Application No: AW/325/21/HH
Site Address: Blue Haze 37 The Drive Aldwick PO21 4DT
Description of works: Erection of single storey side/rear extension, front porch extension and detached garage to front
(This application may affect the character and appearance of the Craigwell House, Aldwick Conservation Area)

Thank you for your internet representation made on 10th November 2021 which has been recorded as an objection with the comments as follows:

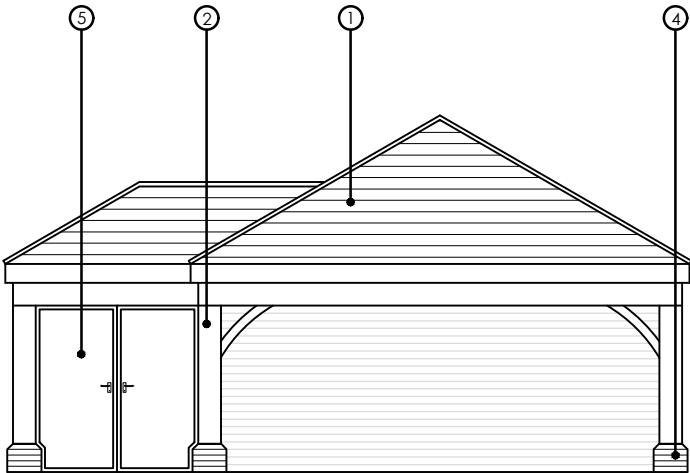
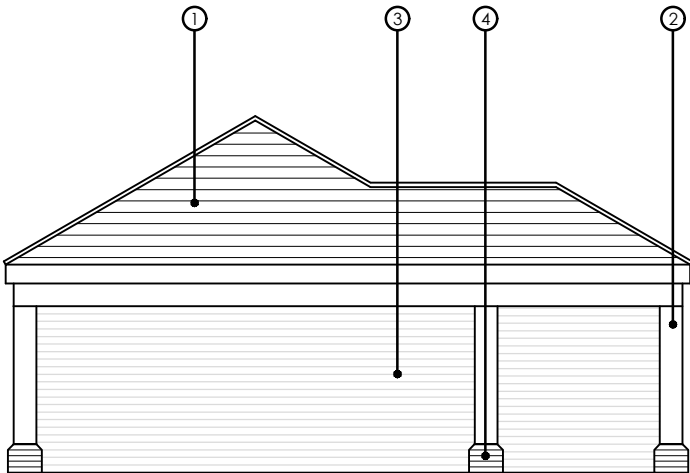
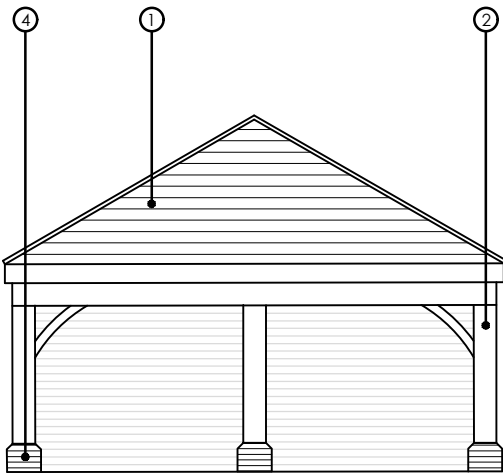
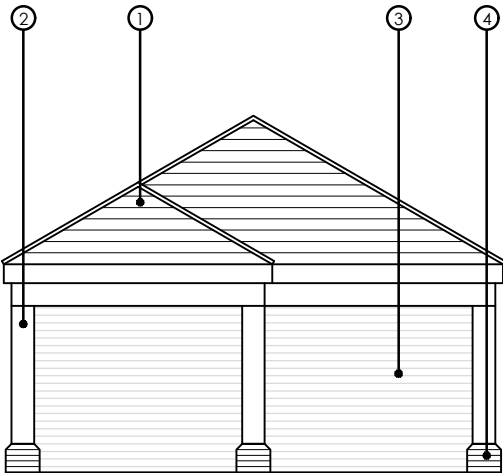
I am concerned that the car port/garage/store building proposed for the front garden will appear intrusive and out of character with the immediate neighbourhood. From the elevation drawings, the apex of the proposed roof seems to be about the same height as the eaves of the existing building.
